From: Tybie House [REDACTED]
Sent: 19 August 2026 15:41
To: Neil Crowther; Planning; Planning.Responses
Subject: A/44/26/PL BRE DG365 testing
Attachments: BRE_Email.pdf

BRE's conclusion is that **"there shouldn't be a long gap between tests 2 and 3"**. This concurs with both the position we have previously set out and the independent engineering review already provided to ADC.

We therefore ask, again, how the Southern Testing report can properly be relied upon as evidence of infiltration testing undertaken in accordance with BRE 365, given that the recorded testing sequence included a 12-day gap between the second and third fills.

BRE DG365 Soakage
testing results

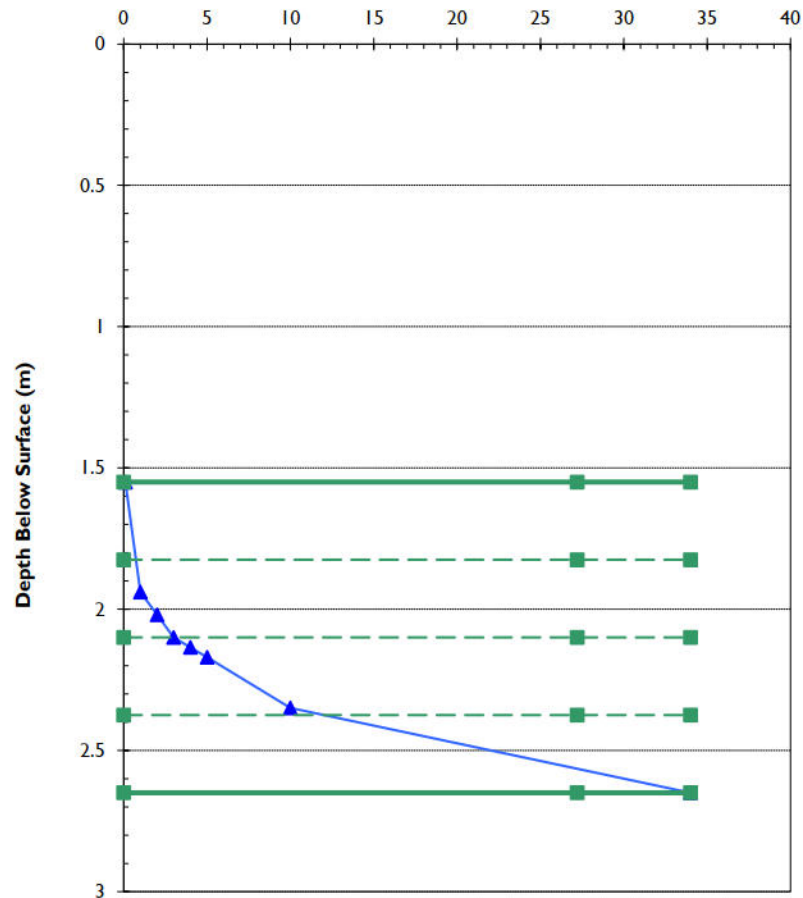
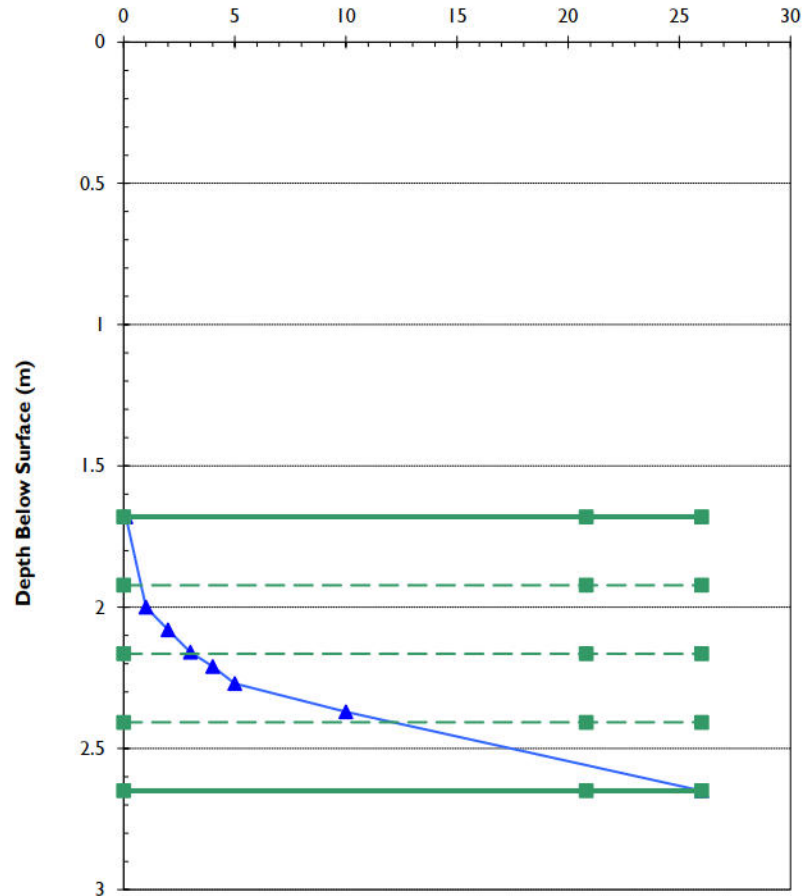
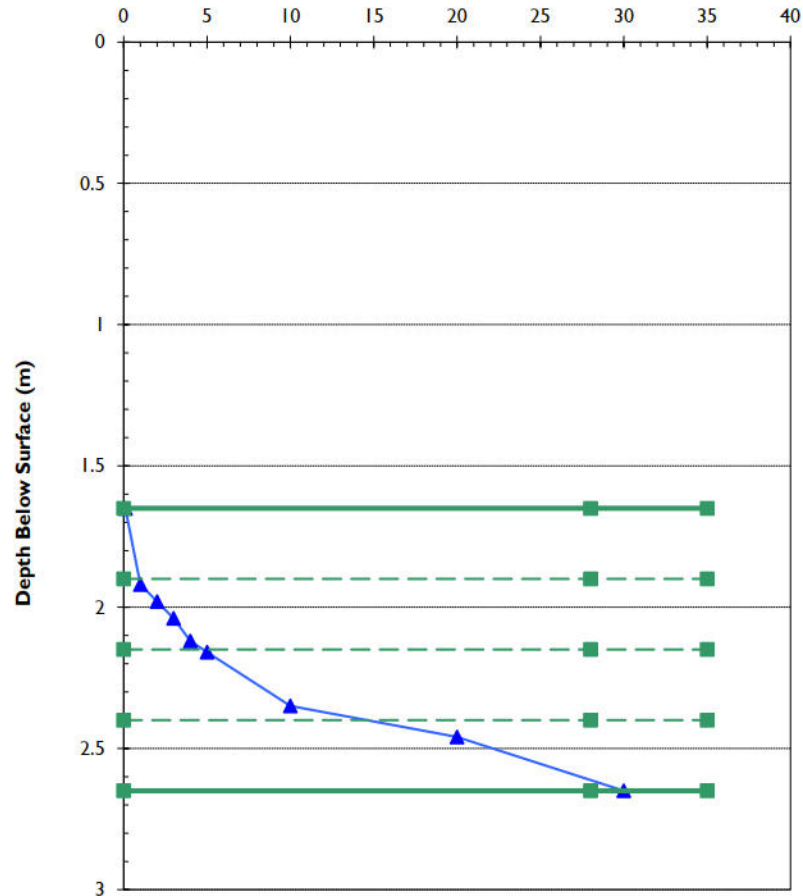
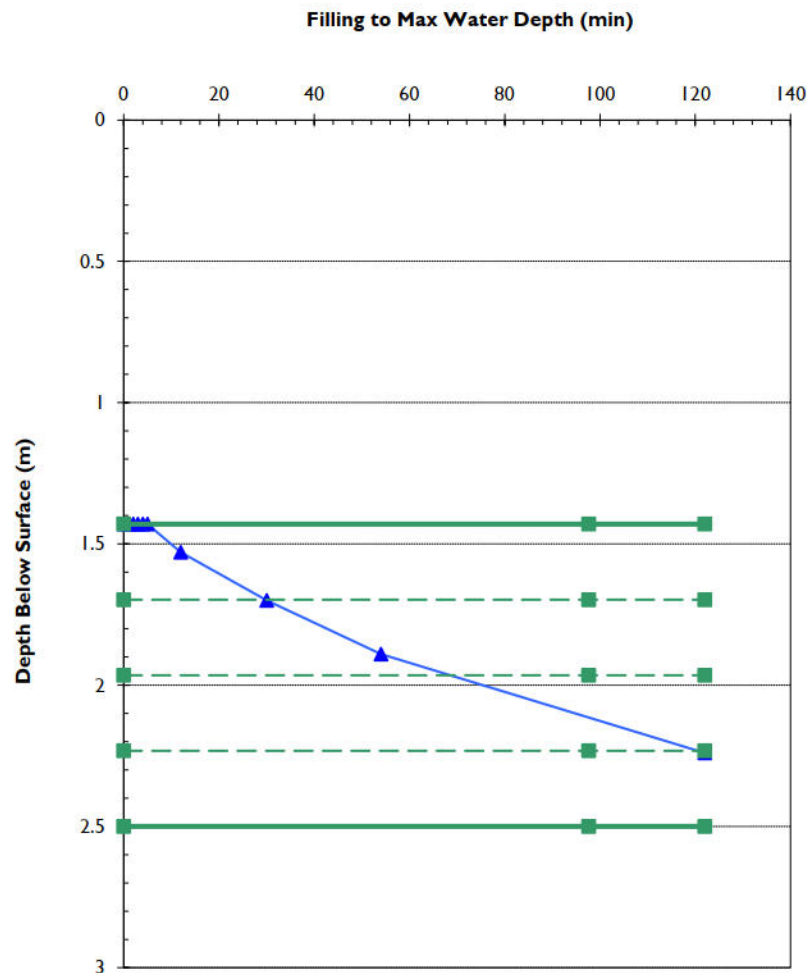
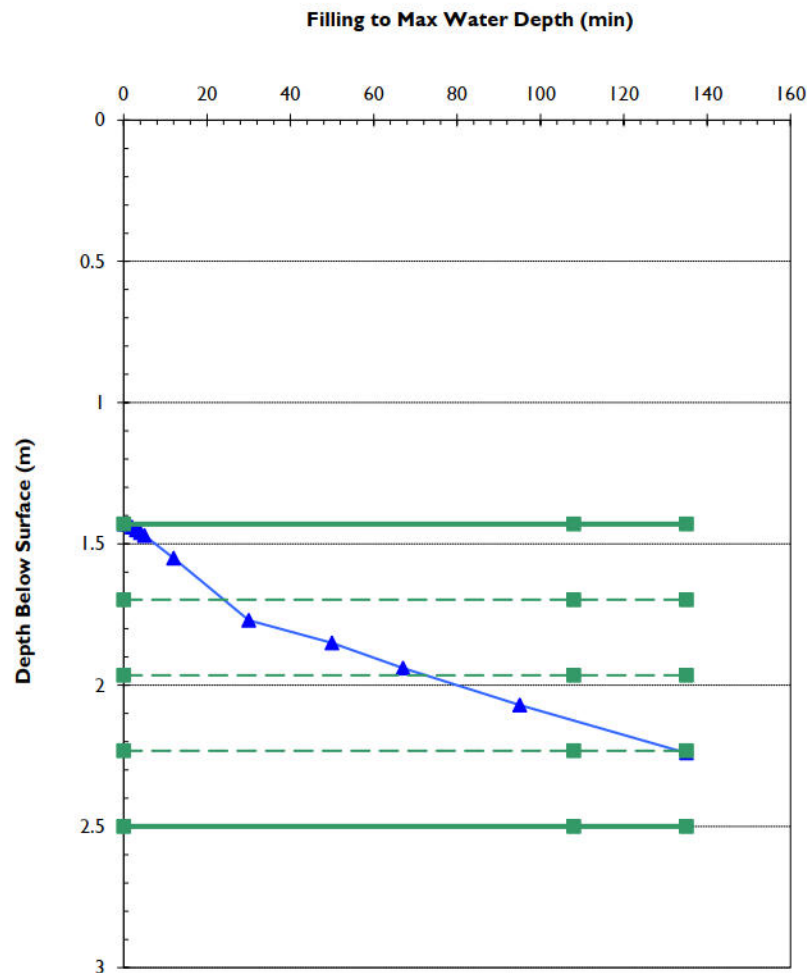
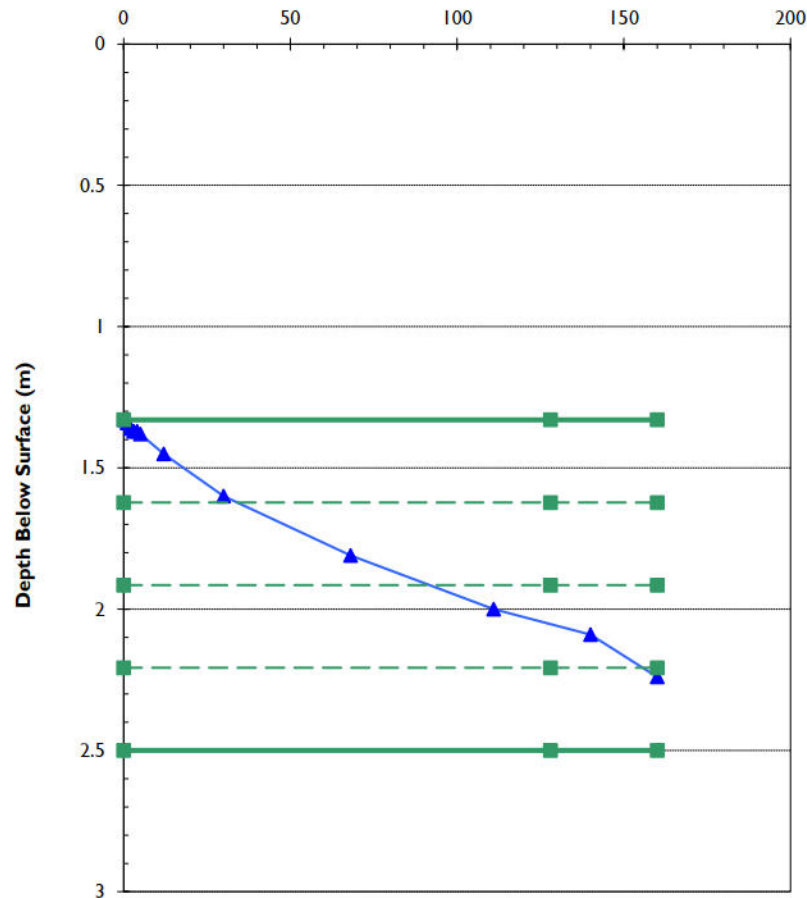
Fill the soakage trial pit and allow it to drain three times to near empty. Each time record the water level and time from filling, at intervals sufficiently close to clearly define water level versus time (Figure 1). The filling of the soakage trial pit should be on the same or consecutive days.

I've highlighted the relevant text which indicates that there shouldn't be a long gap between tests 2 and 3.
